23 December 2021

**Request for Advice - EIS – ARDEX Warehouse and Manufacturing Facility
SSD- 25725029 at No. 657 – 769 Mamre Road Kemps Creek**

Super B-Double Quad-Quad
 Overall Length 29.865m
 Overall Width 2.500m
 Overall Body Height 4.300m
 Min Body Ground Clearance 0.540m
 Track Width 2.500m
 Lock-to-lock time 15.000m

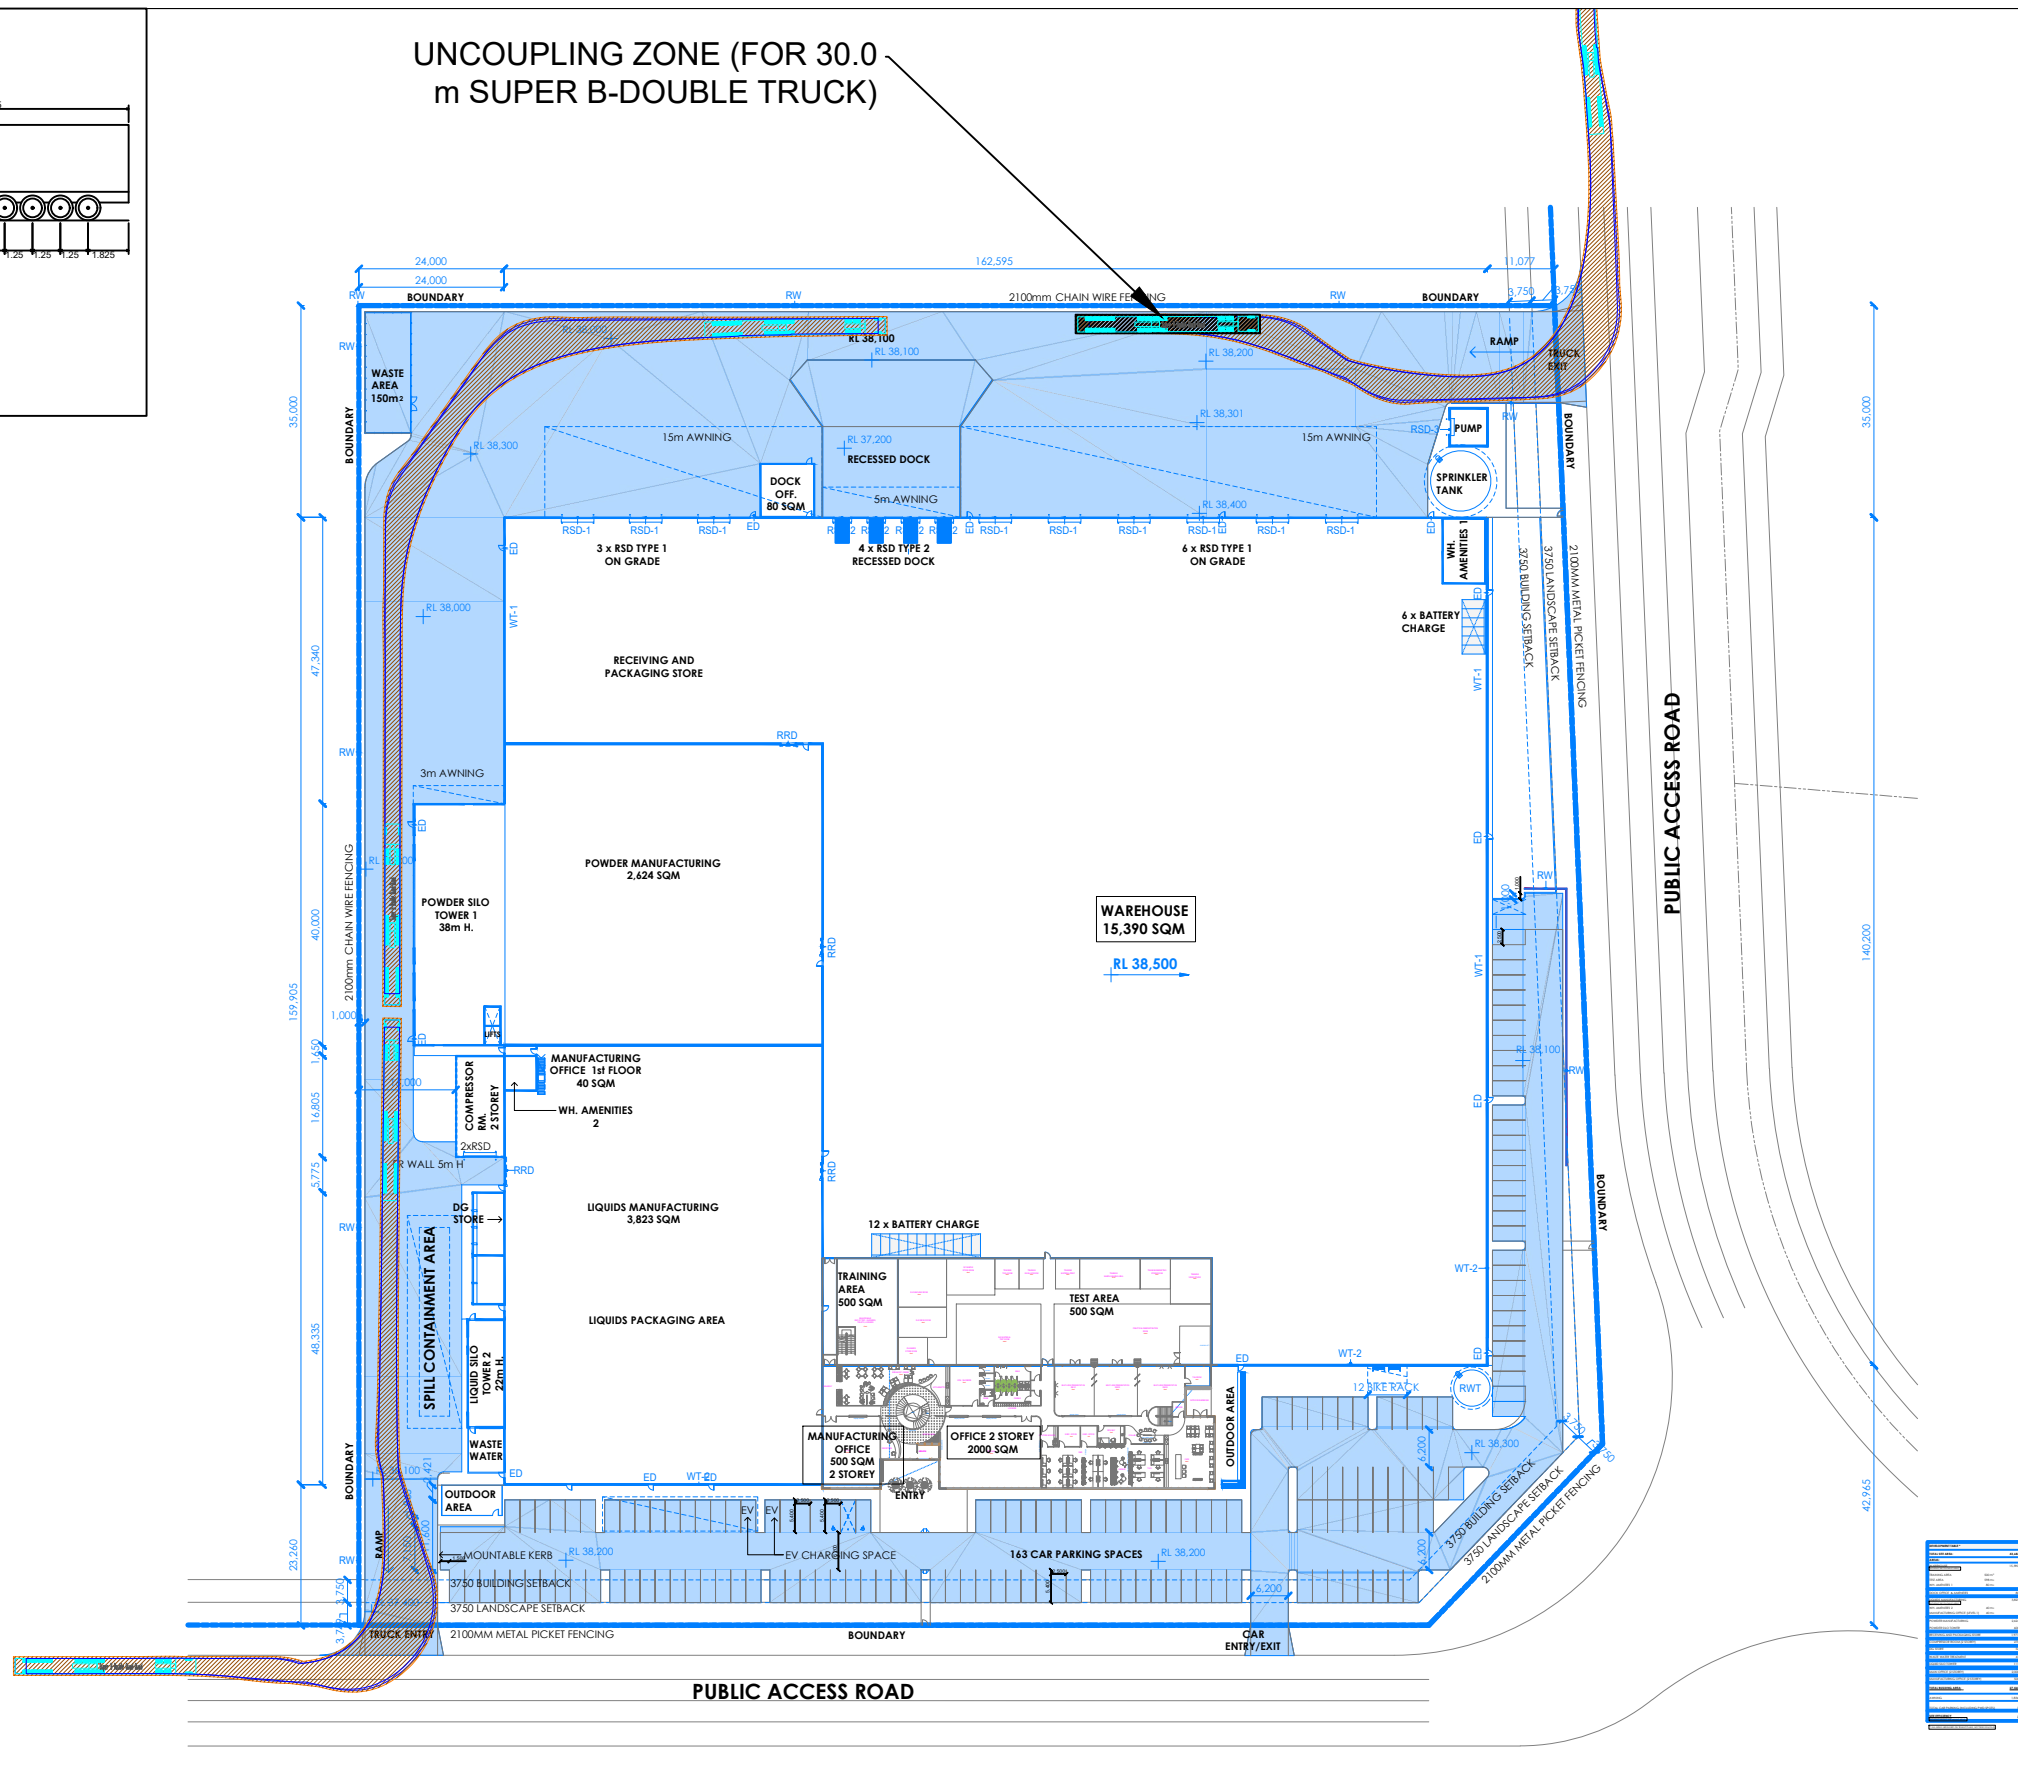
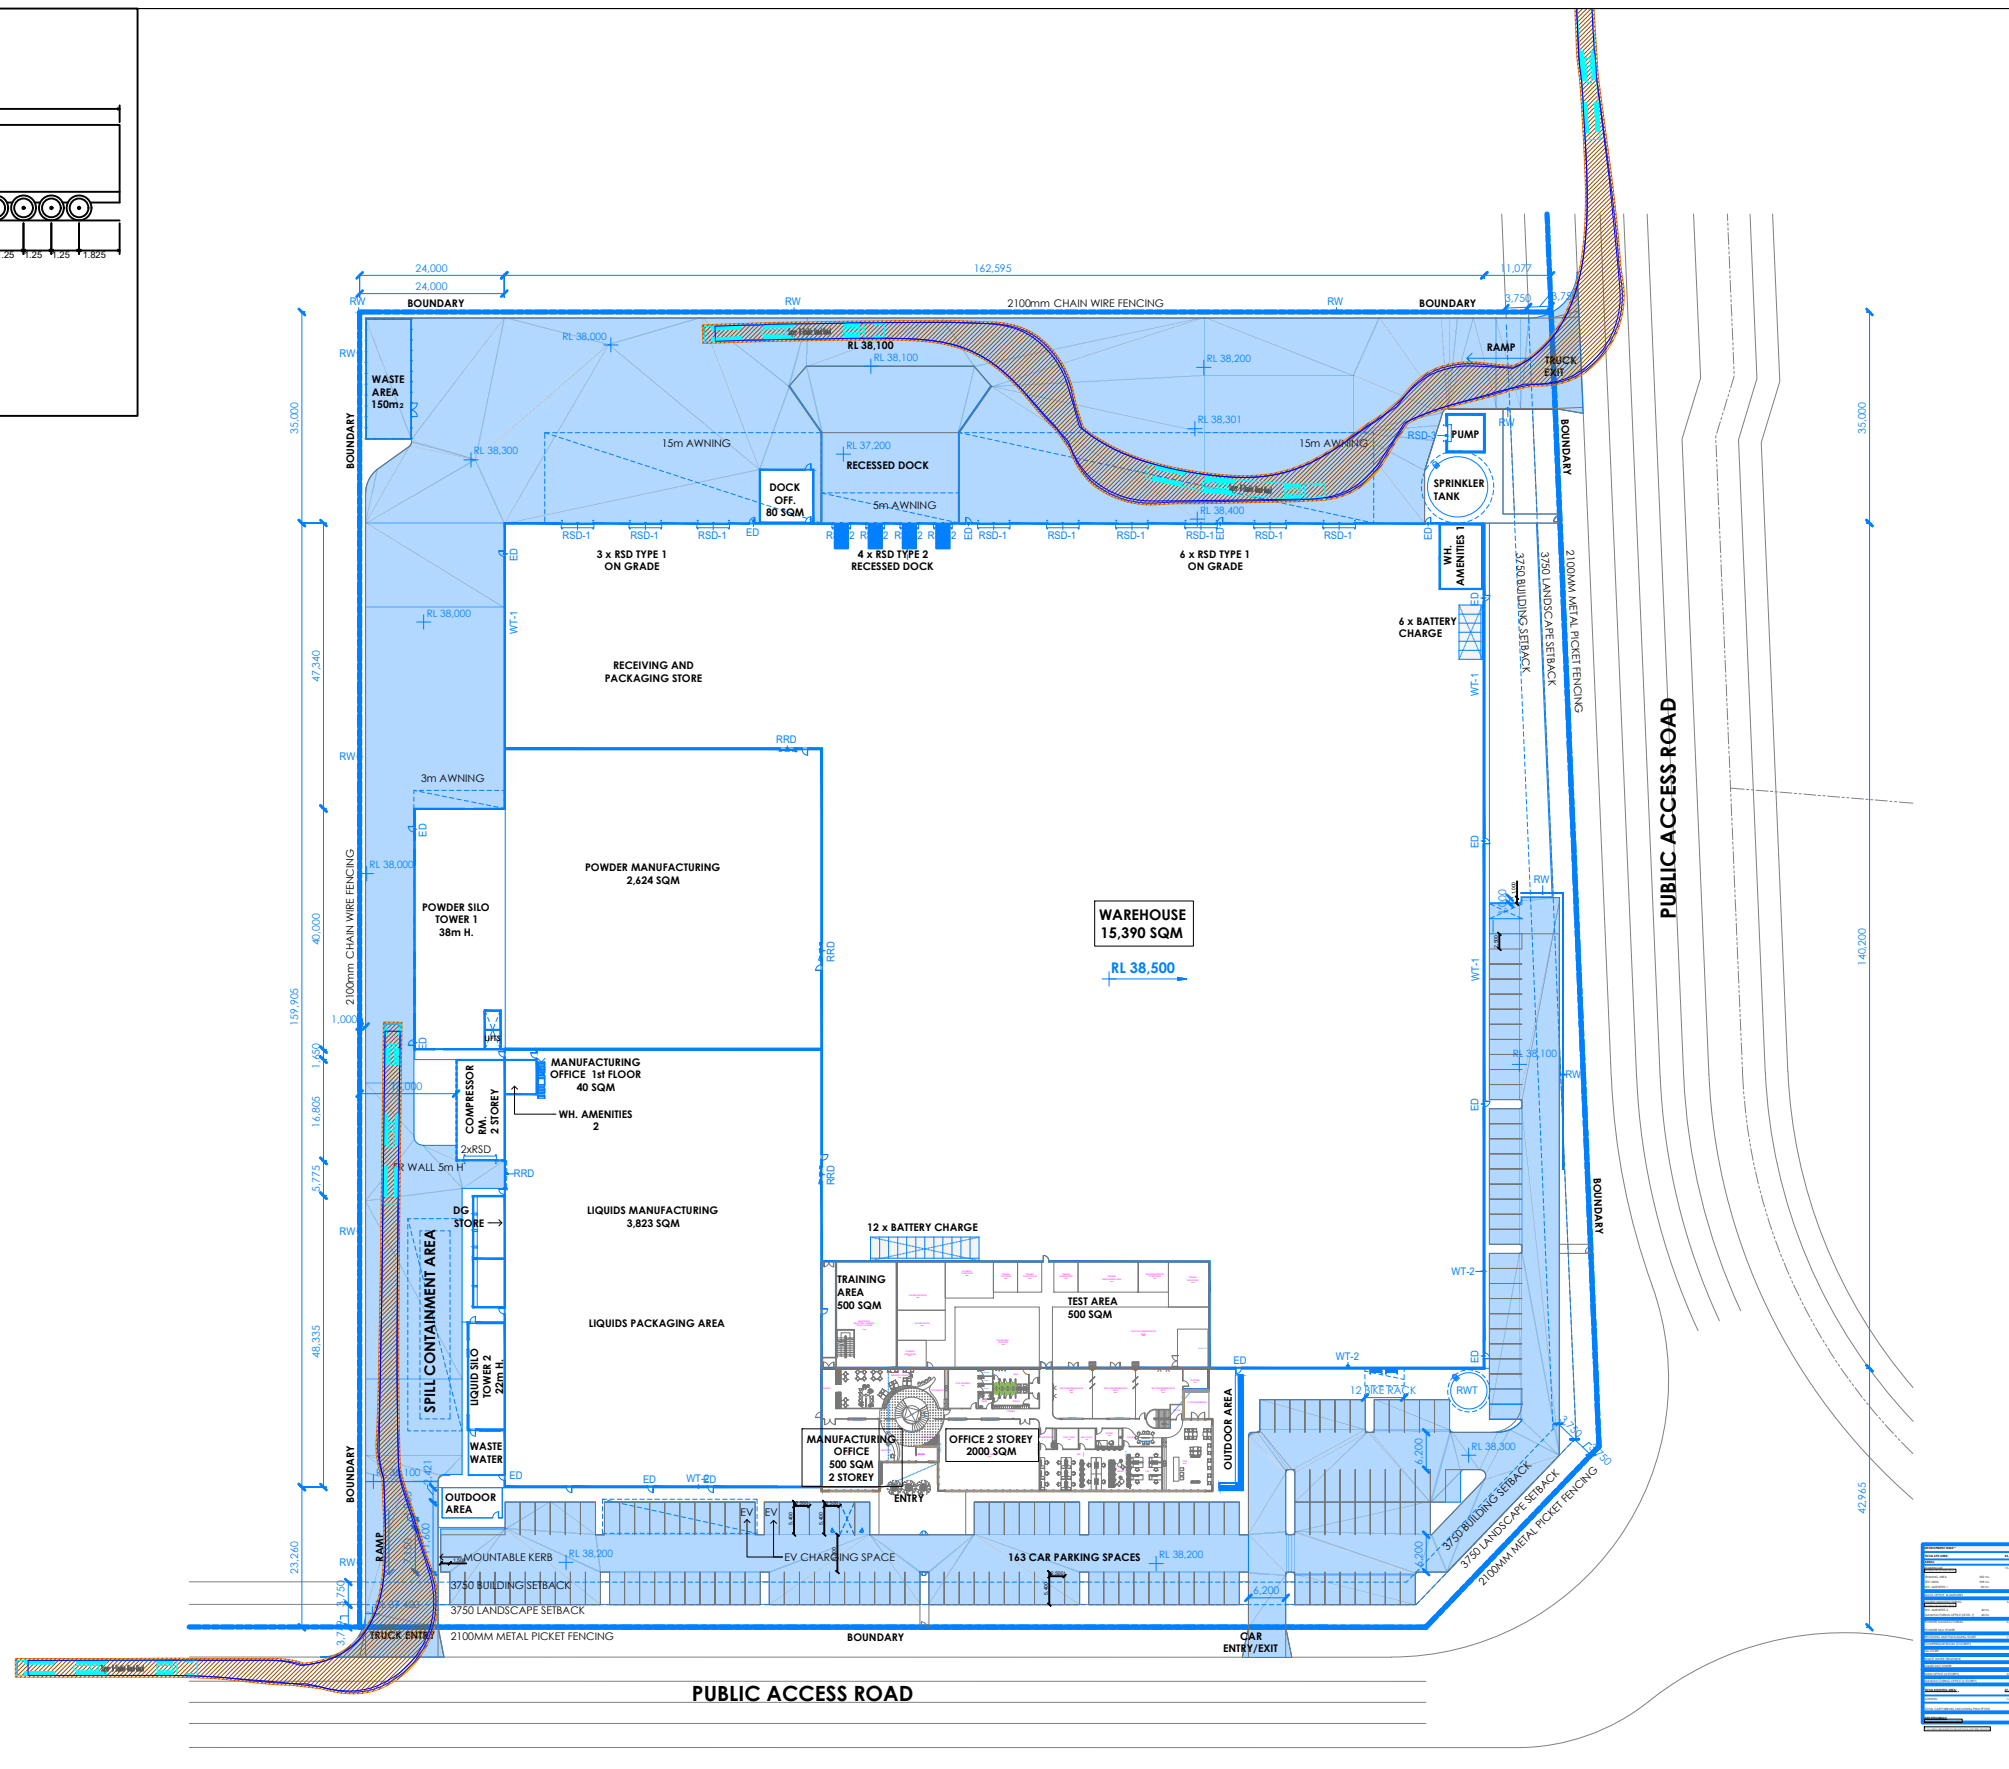
Turn path diagrams provided in the Transport Assessment report by Ason Group dated 05.11.2021 show a Super B-Double Quad-Quad heavy vehicle entering and exiting the site by encroaching over the frontage of the adjoining lot within the verge area, which is not supported.

Vehicular driveways and crossovers are to be wholly contained within the development frontage so as not impact upon any future adjoining development.

Revised turn path diagrams are to be provided demonstrating compliance for the following:

- Site access for 30m Performance Based Standards (PBS) Level 2 Type B vehicles and tested for a 36.5m PBS Level 3 Type A vehicles

- (a) The applicant proposes for 30-metre-long super B-Doubles to access the site however, Council understands is that the surrounding roads are only designed to cater for 26 metre long B-Doubles. Therefore, the use of super B-Doubles or any other heavy vehicle larger than a 26 metre B-Double is not supported.
- (b) Any gates to the site should be located so that the largest vehicle is contained within the boundary of the site when the gate is closed.
- (c) Although it is noted that consent SSD-9522 requires 1% of parking spaces to be provided with Electric Vehicle Charging Stations (**EVCS**), in order to future proof the development, Council recommends the adoption of a rate of 10% of car parking space to be provided with EVCS.
